From: Laura Gibbons <Laura.Gibbons@arun.gov.uk>
Sent: 14 September 2021 09:36
To: Planning.Responses <Planning.Responses@arun.gov.uk>
Cc: Simon Davis <Simon.Davis@arun.gov.uk>
Subject: RE: Planning Re-Consultation on: BN/98/21/DOC

Application No: BN/98/21/DOC

Site Address: Land North of 1 Northfields Cottages Fontwell Avenue Eastergate PO20 3RX

Description of Works: Approval of details reserved by condition imposed under BN/50/20/PL relating to conditions 5, 7, 8, 10, 11, 13, 17, 18 & 20.

DRAWING NUMBER:
L02

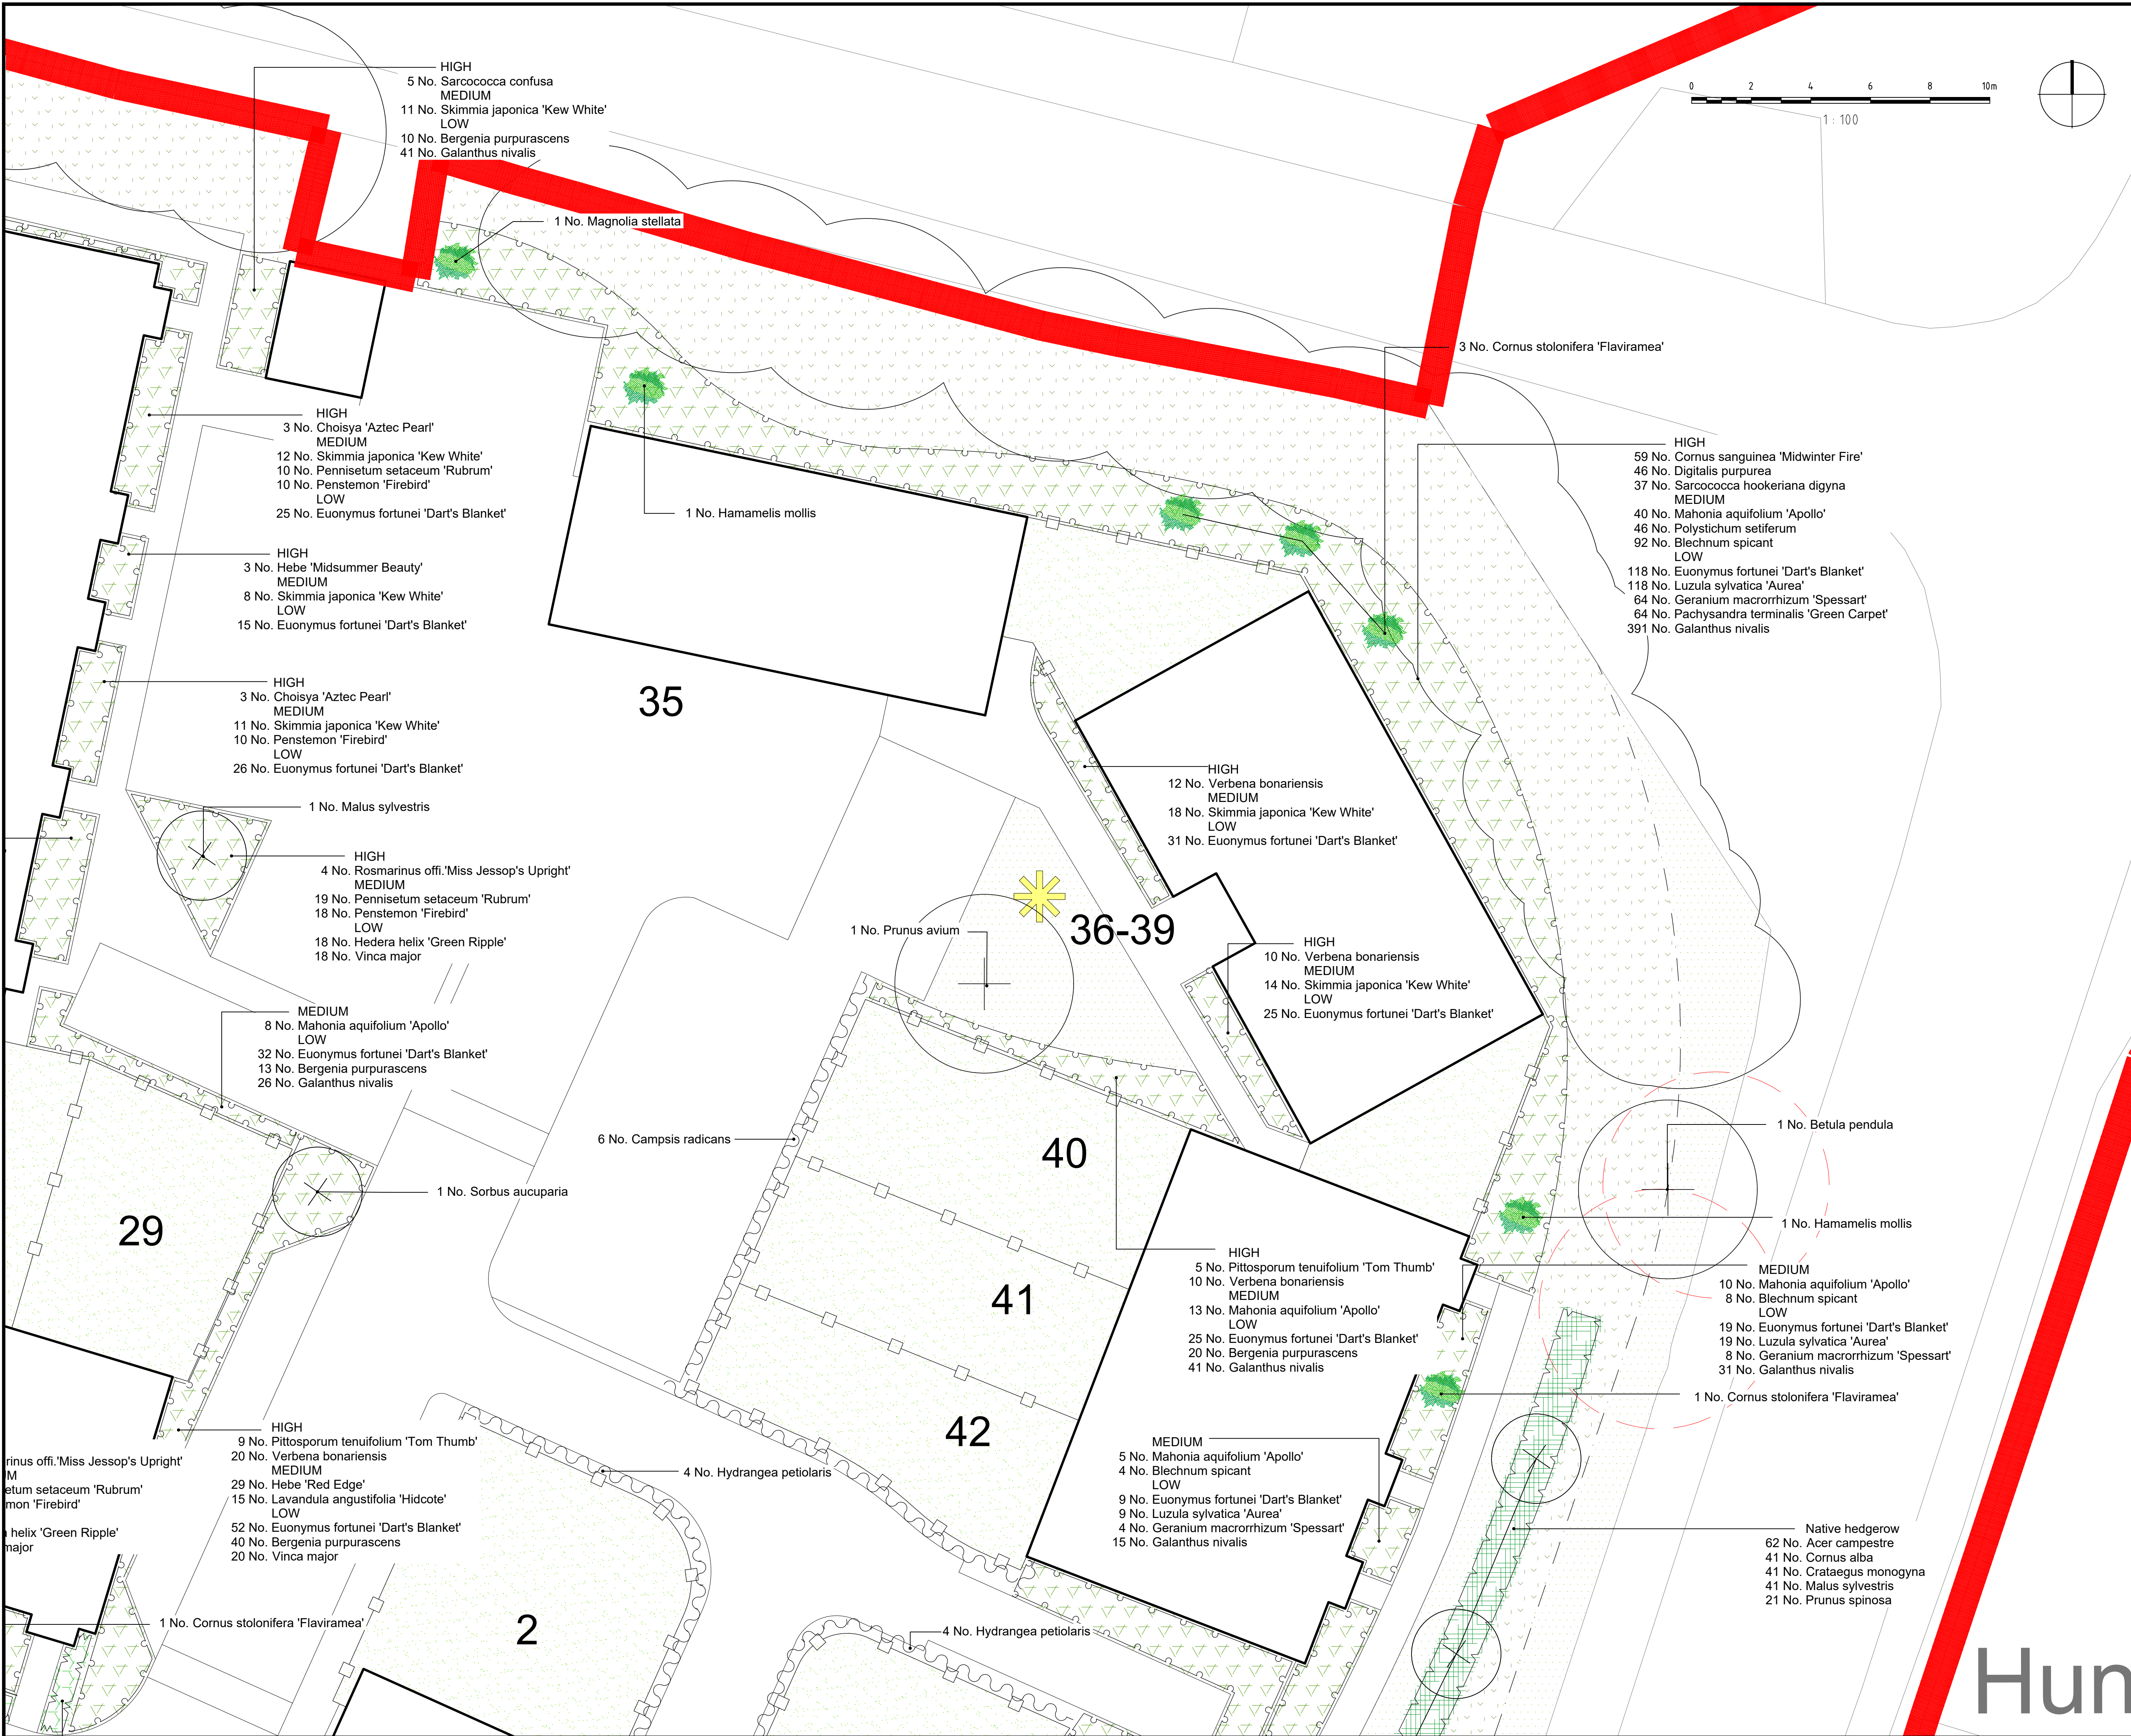
15. There is still conflict between planting plans and drainage layouts, i.e. trees over/ very close to infiltration crates.
16. Please re-consult Porstmouth Water regarding condition 10 now that proposals have crates as low as 2.57m depth.
